Subject: RE: Y/82/21/DOC - Land east North End Rd - CONTAMINATION - URGENT QUERY PLEASE!

Plan 1

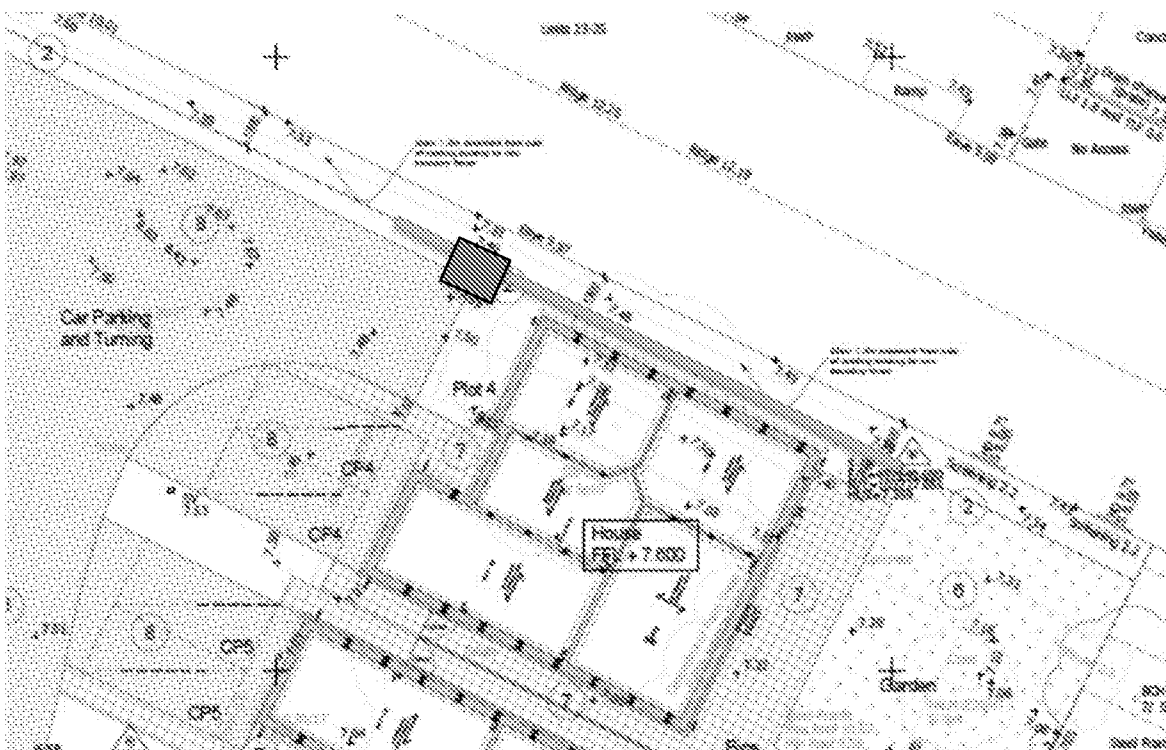
From a contaminated land perspective, EH has no issue with works continuing (subject to point two of my below e-mail being satisfied), however we can't recommend full discharge of the condition due to the required validation report (which of course can't be supplied until the groundworks are complete). The second point of my below e-mail could be remedied with an update to the existing submission...

1. there is a validation on completion of groundworks required
2. whilst I agree with the majority of the recommendations, the scope should be broadened to include the extent of the buried wall (this should not be executed under the discovery strategy provisions) and detail of an appropriate cover system. The usual recommendation is a minimum of 600 mm clean material or 300 mm clean material over a suitable geotextile membrane.
